**Ref 2022/1201**

Description: Erection of three storey building containing 6no studio apartments  
(Outline seeking approval over layout, scale, appearance and means of access)  
(Amended Address)

Site Address: Land adjacent 1-4 Springfield Street, Barnsley, S70 6HH.

PROPOSED GROUND
FLOOR PLAN
SCALE 1:50

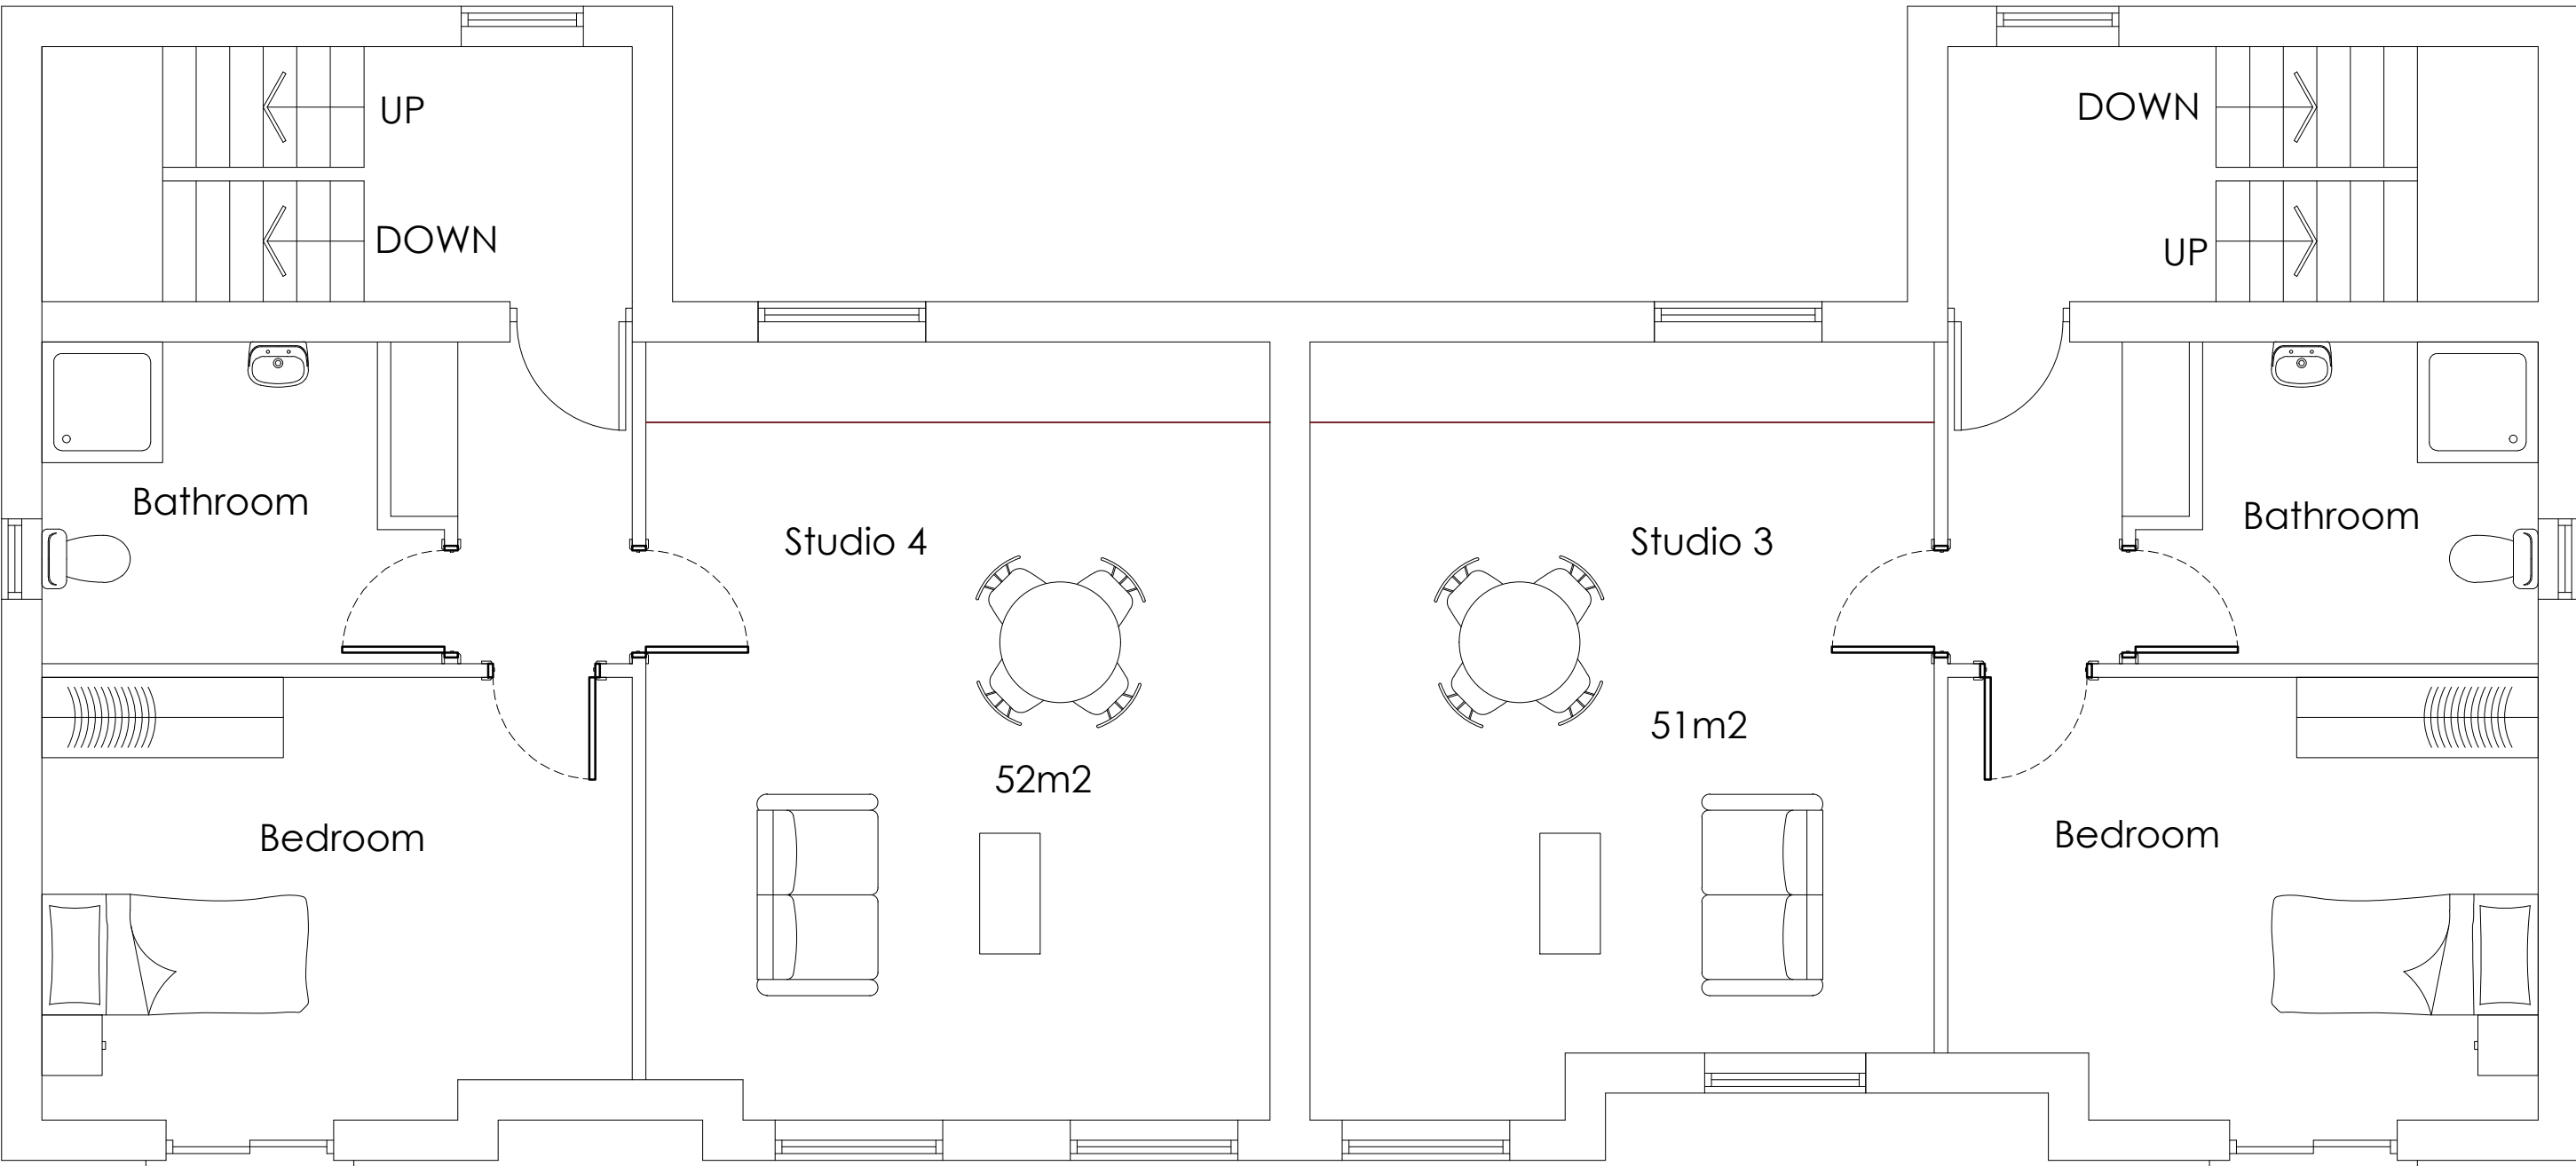
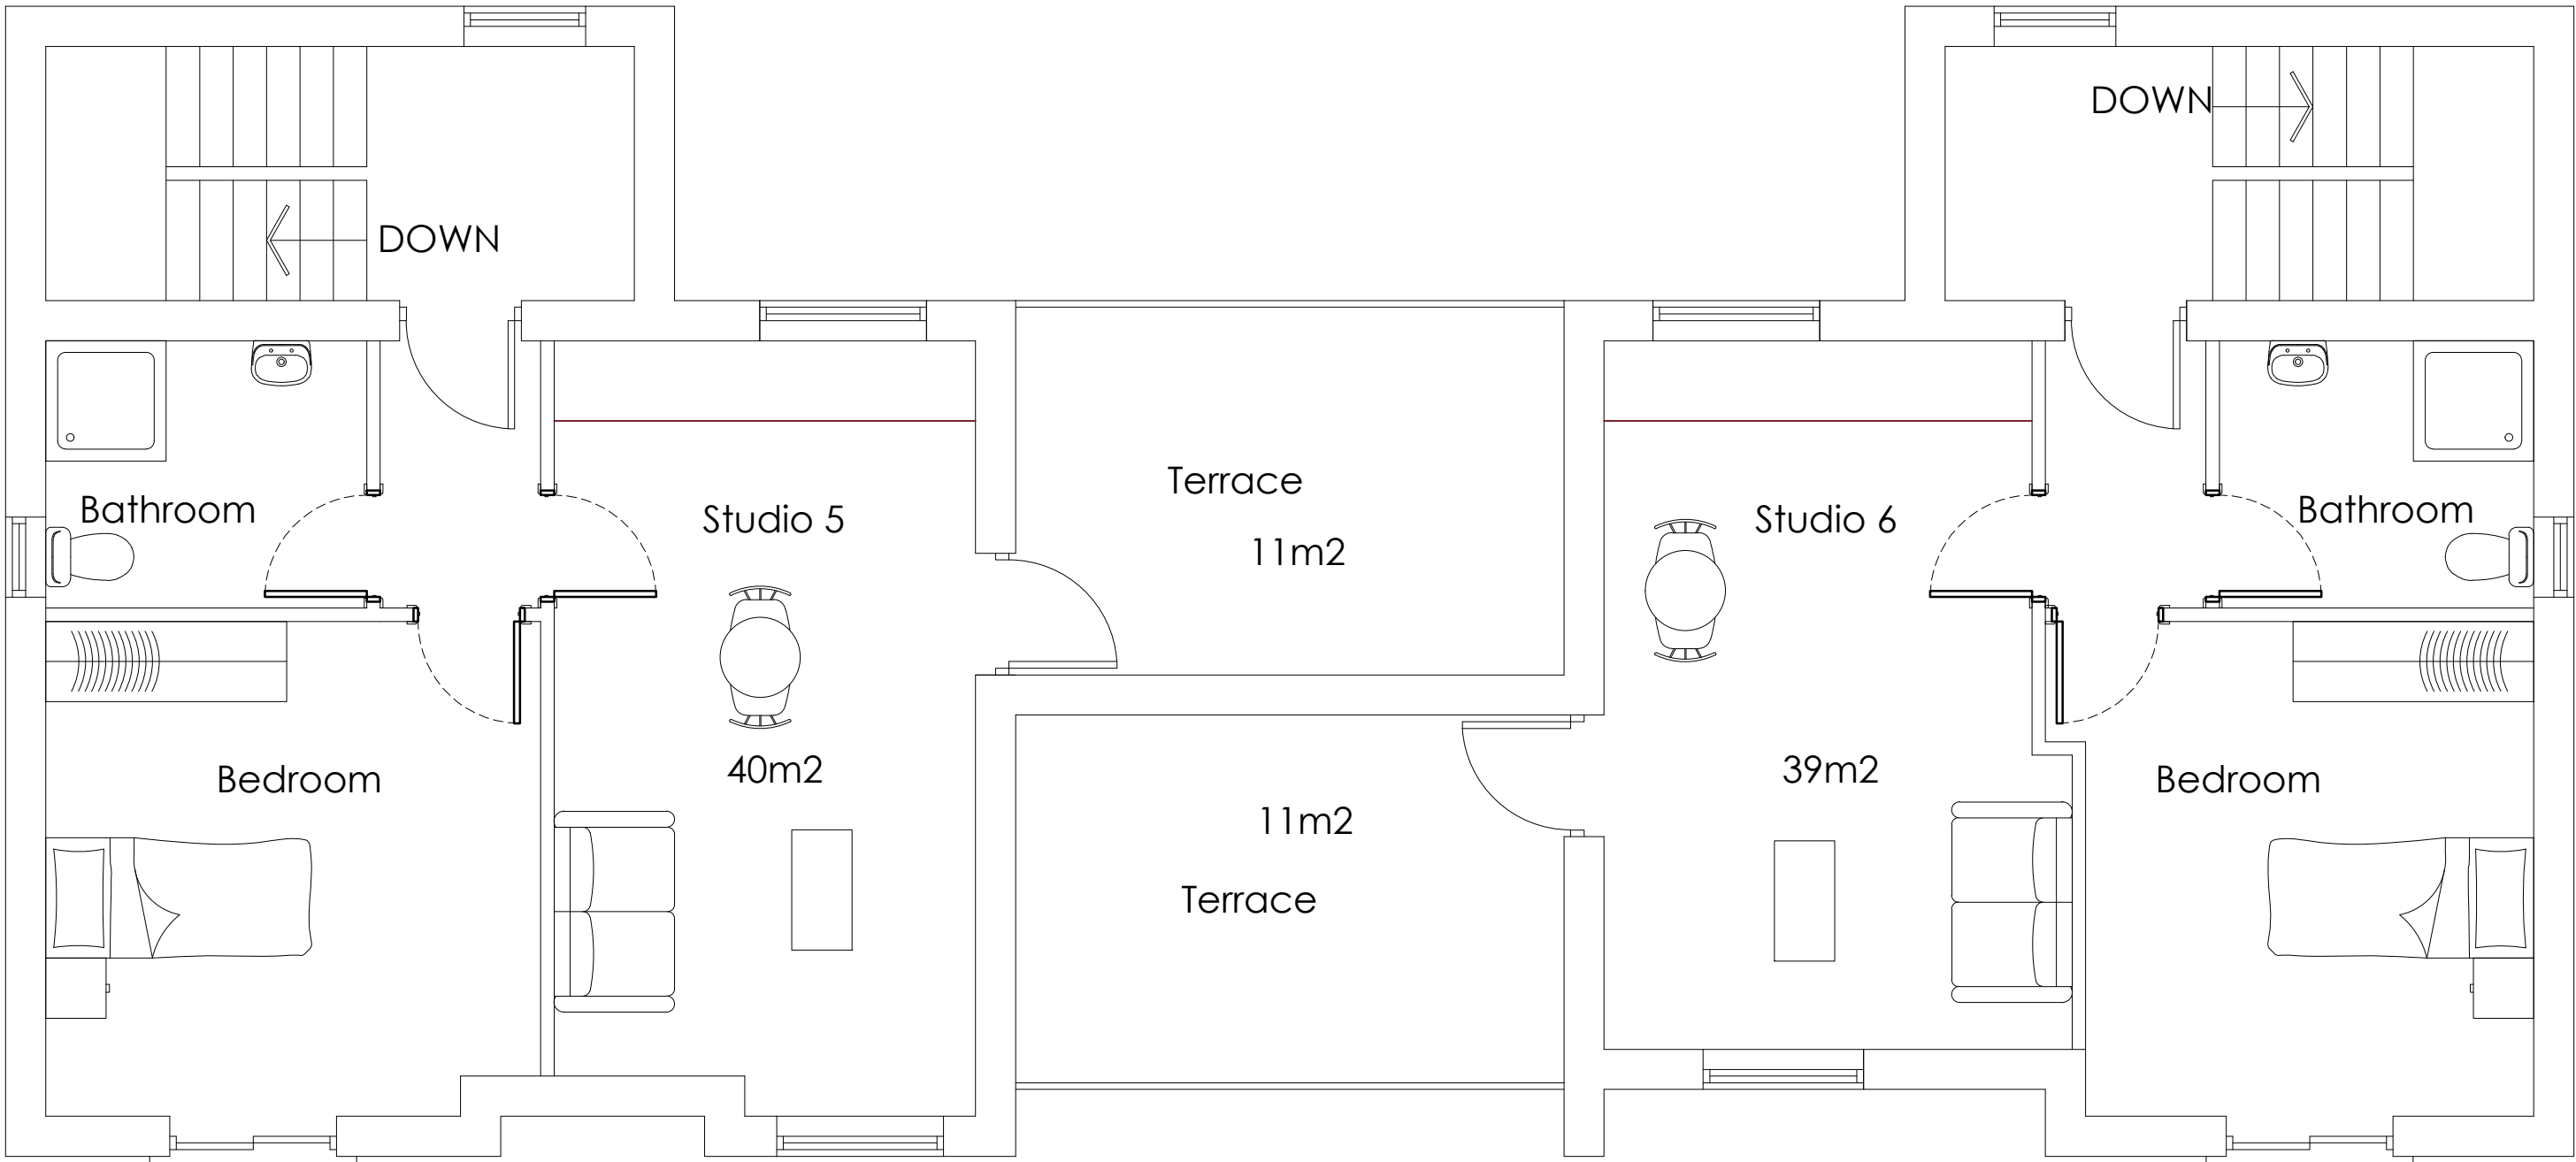
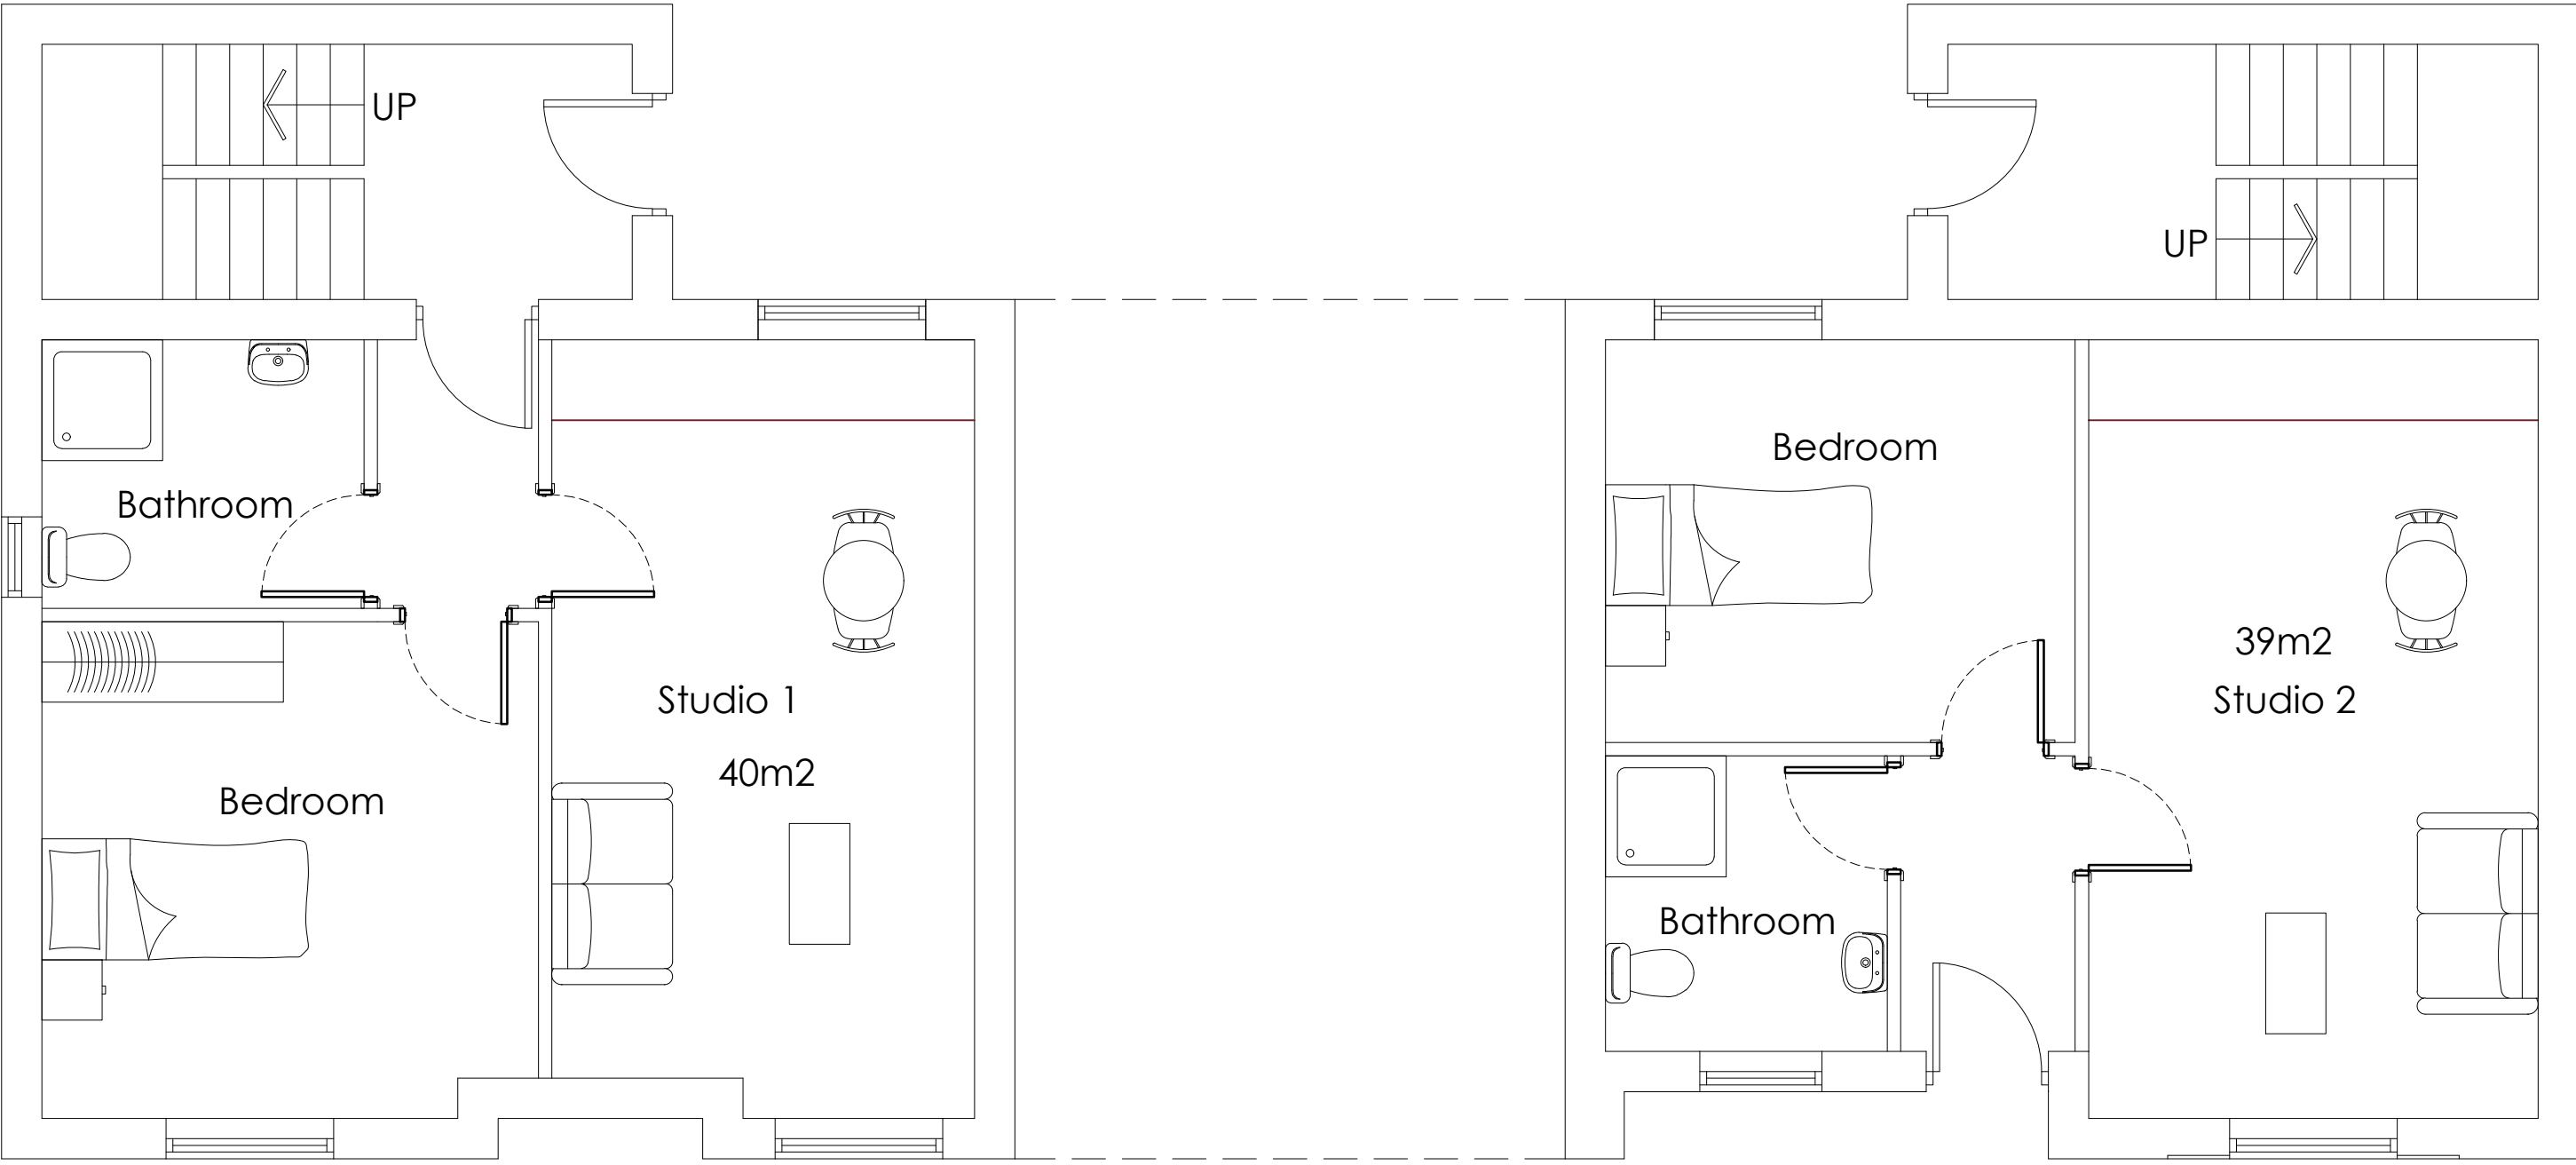
In terms of the future residents, the flats/apartments are labelled as studios on the drawings, however, they have separate bedrooms, as such, they will be assessed as 1 bedroom apartments in terms of internal spacing. In accordance with the South Yorkshire Residential Design Guide a 1 bedroom, 2 person flat should be 47m<sup>2</sup>, however, studios, 1, 2, 5 and 6 fall considerably short of the requirement. The SPD also states that flats should have 50m<sup>2</sup> of shared garden space plus 10m<sup>2</sup> per unit where a balcony cannot be provided. Only flats 5 and 6 have access to a roof terrace.
